Project Name: DURAN & ALEXANDER ADDN

**CITY OF ALBUQUERQUE
PLANNING DEPARTMENT
July 23, 2014
DRB Comments**

RE: Block C, Duran & Alexander Addition

8. **Project# 1010103**
14DRB-70196 MINOR - SDP FOR
BUILDING PERMIT
14DRB-70252 MINOR - PRELIMINARY/
FINAL PLAT APPROVAL

ANTHEA 4TH AND GRANITE  
 950 4TH STREET - SITE PLAN  
 ALBUQUERQUE, NM  
 PROJECT #388

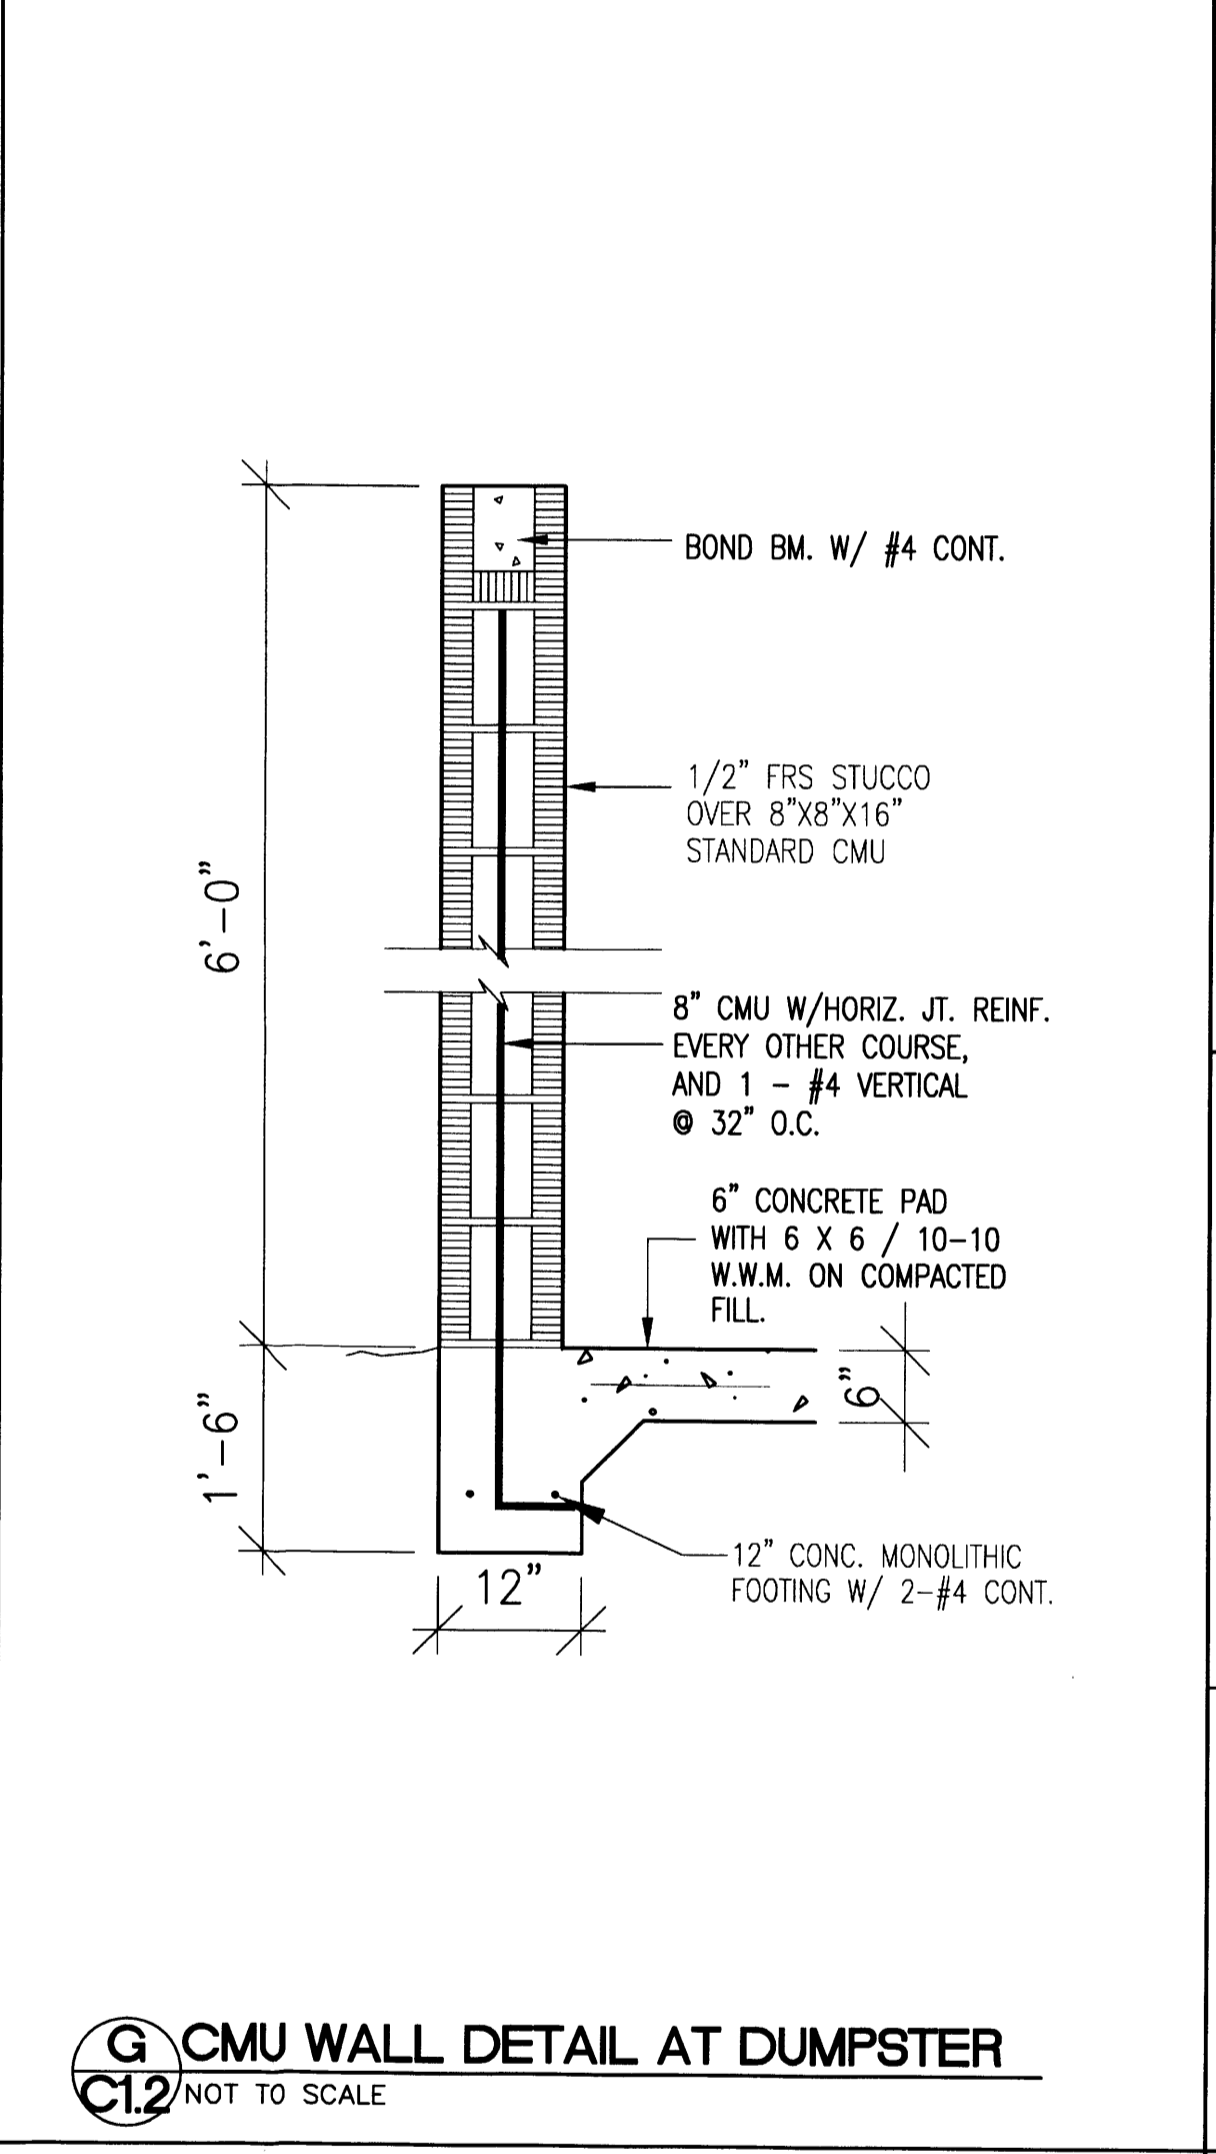
Please correct the calculation in the Parking Table; additionally, there are two parking spaces number 28.

LANDSCAPE CALCULATIONS

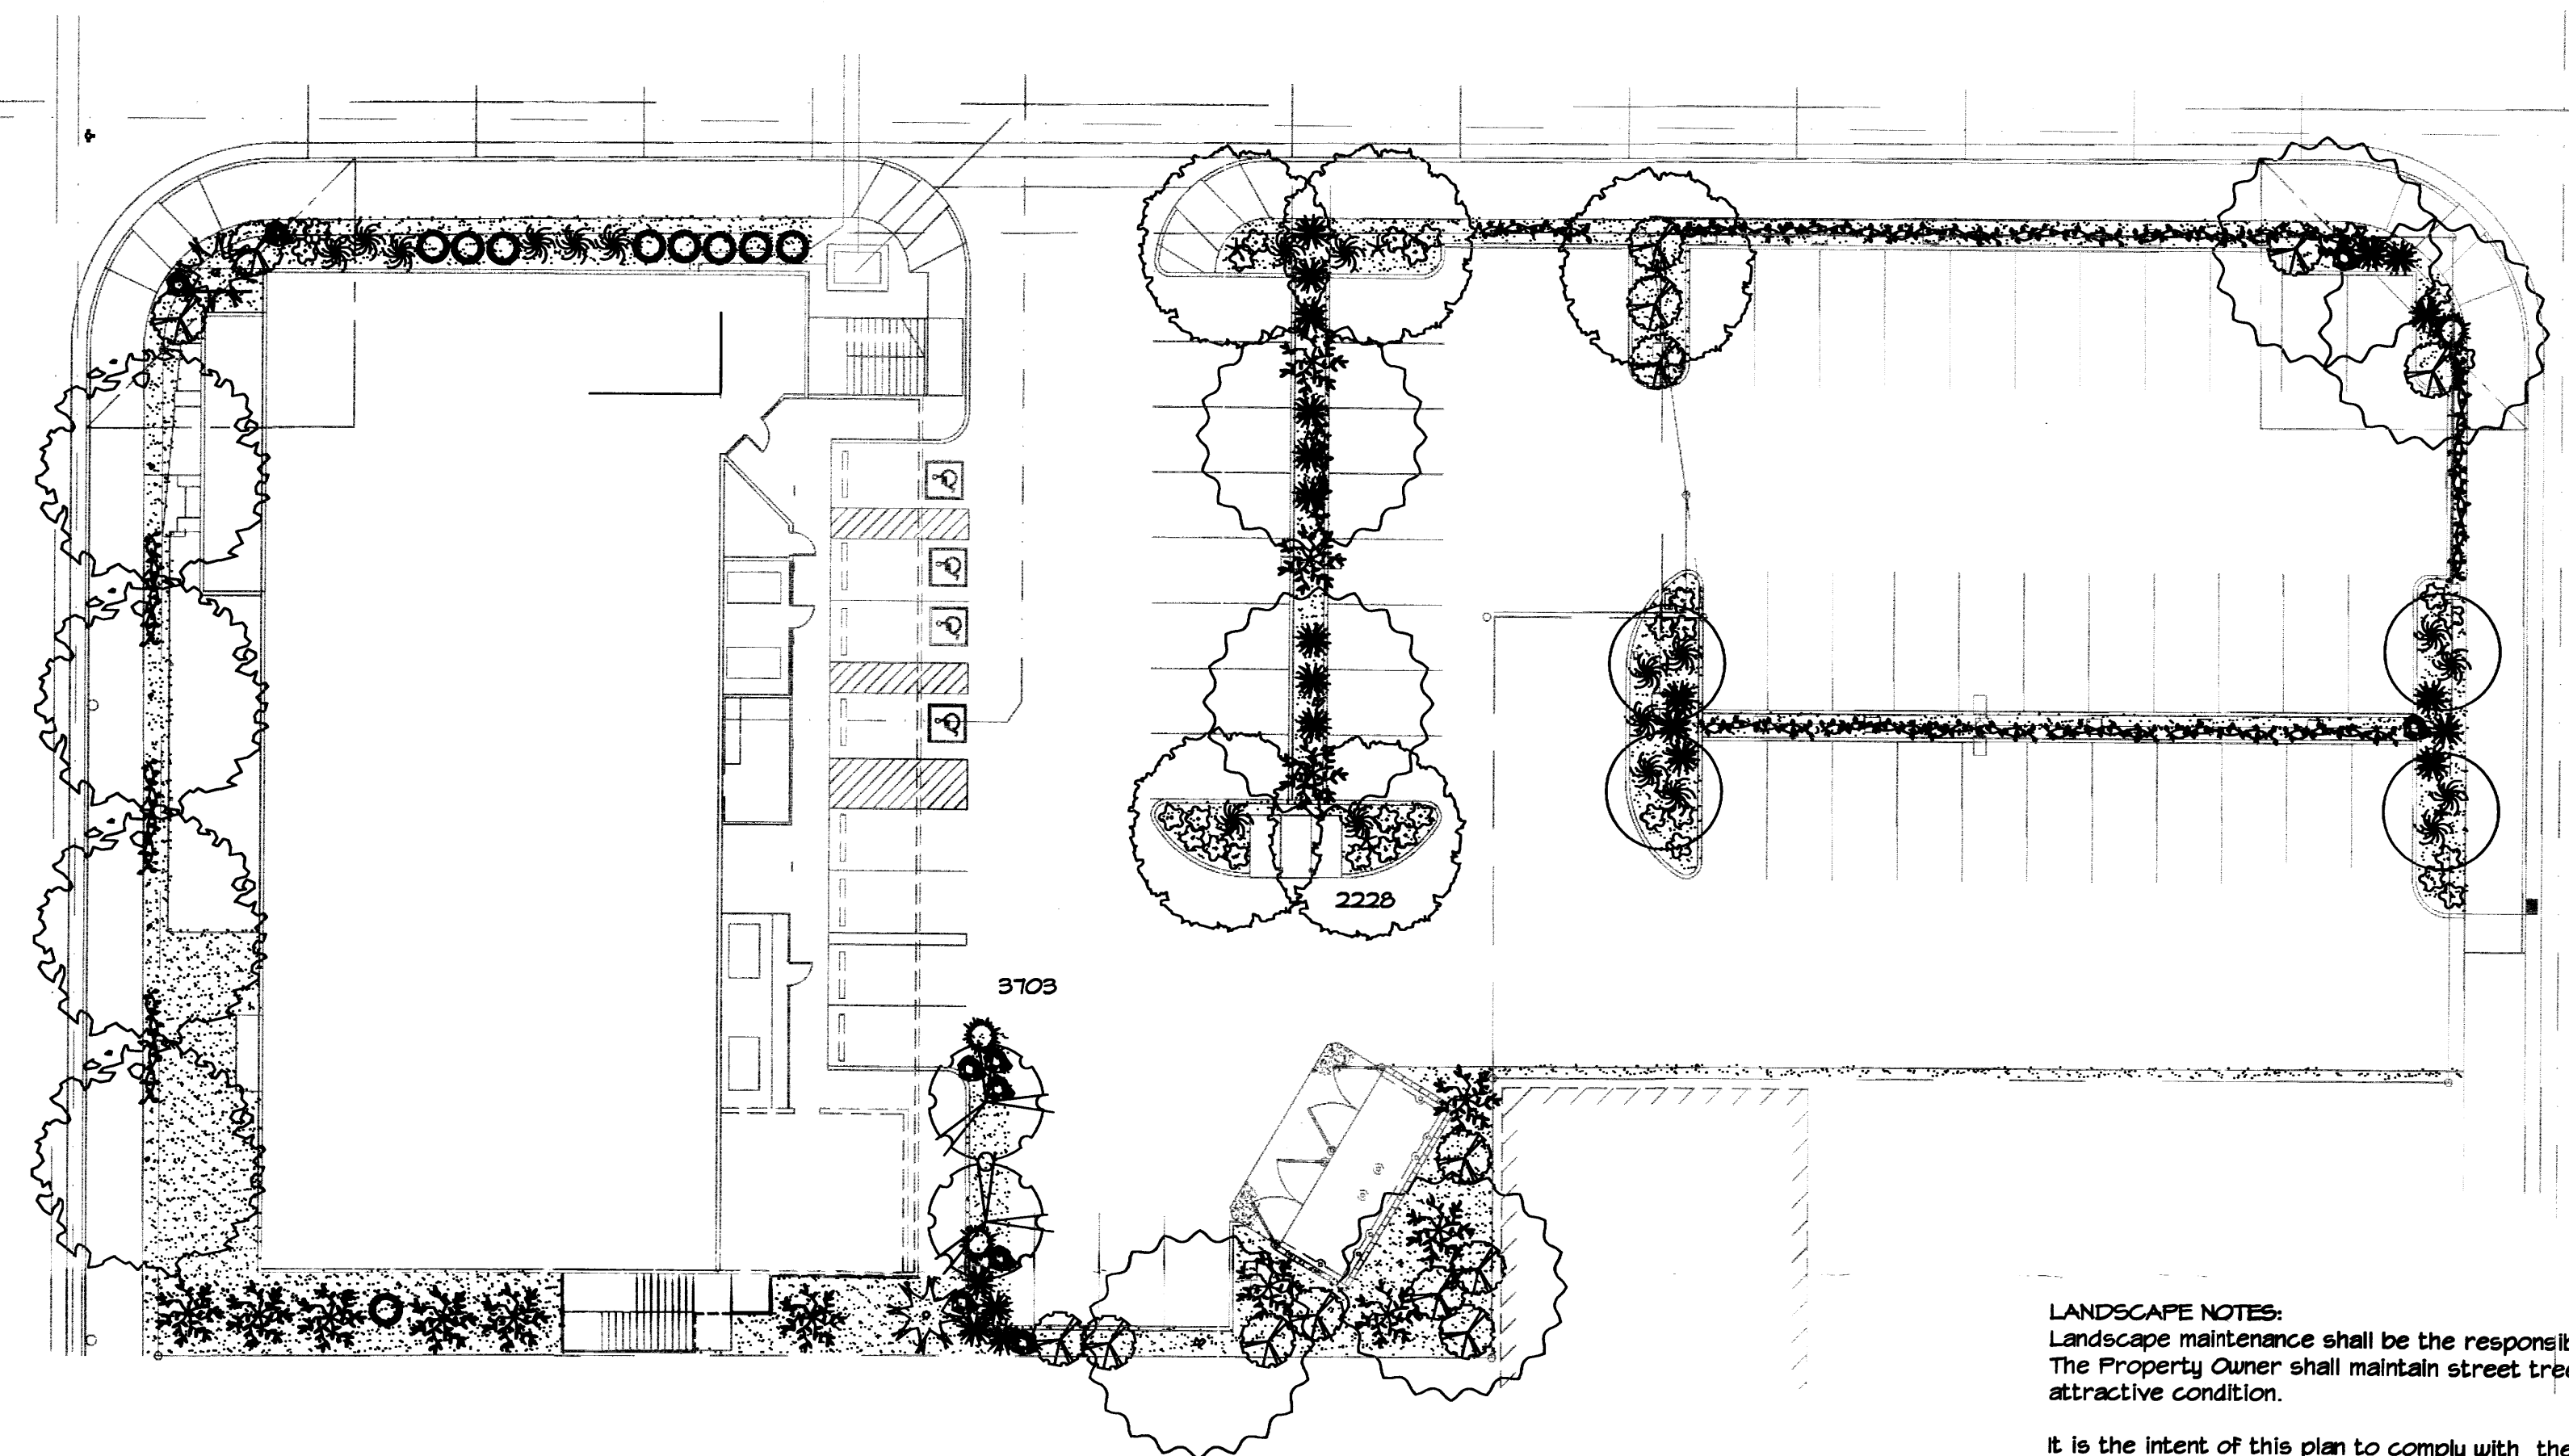
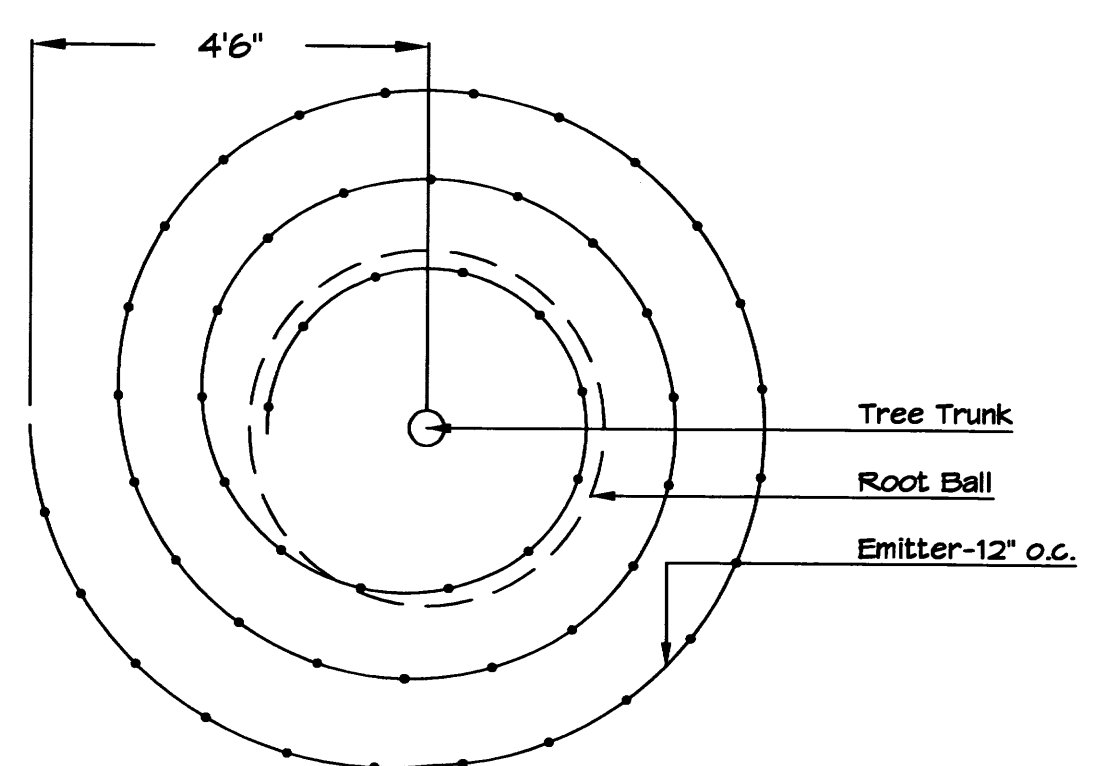
Per site plan, building area = 8,267 sf, so net area for landscaping would be 30,934 sf x 15% = 4,640 sf required.

- o Client is not applying for any on-street parking credits.
- o Keyed notes have been clarified.
- o Landscaping plan has been revised addressing irrigation systems and landscaping.

H BICYCLE RACK
C12 NOT TO SCALE

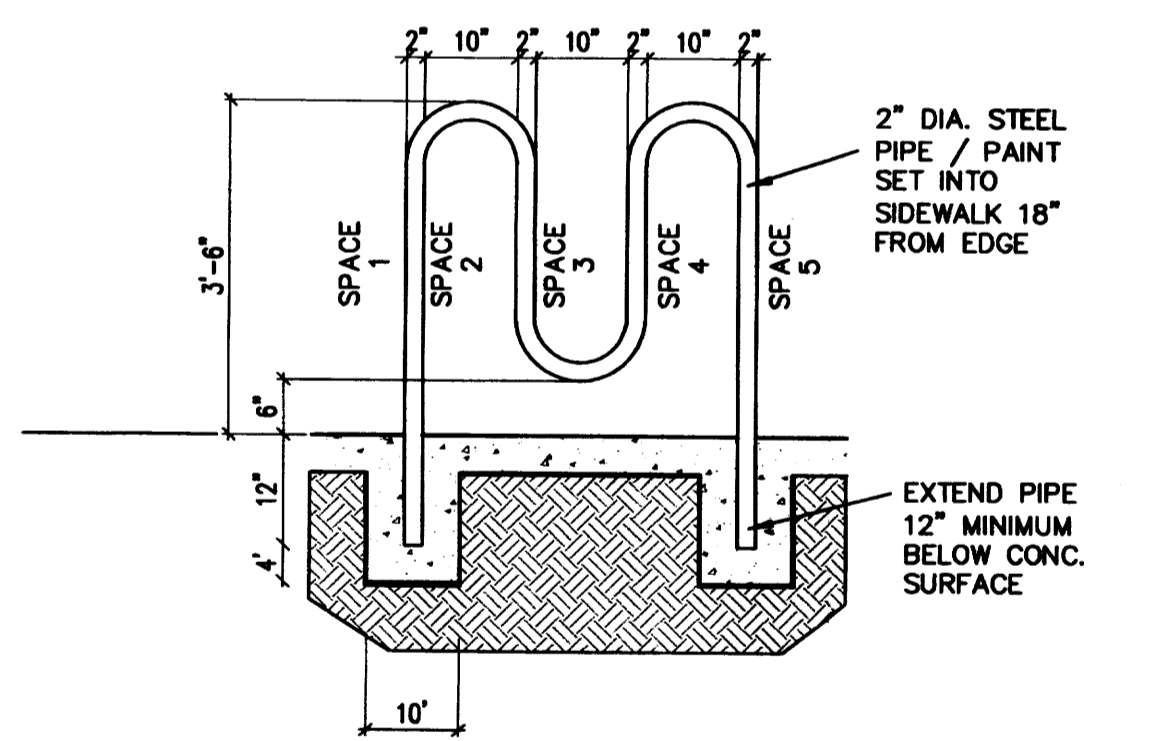
Parking needs to be per Zoning Code, 1/ 200 sf for 1st 15,000 sf Retail net leasable (10,301 sf = 52 spaces); motorcycle parking needs to be visible from building entrance; approval by ABQ Ride is needed for 5% shelter reduction; on-street parking credit requires approval by Traffic Engineer, and only one half of the spaces may be counted if approved; designated disabled parking requirement would be 4 spaces. Bicycle rack needs to be relocated to not obstruct door entry.
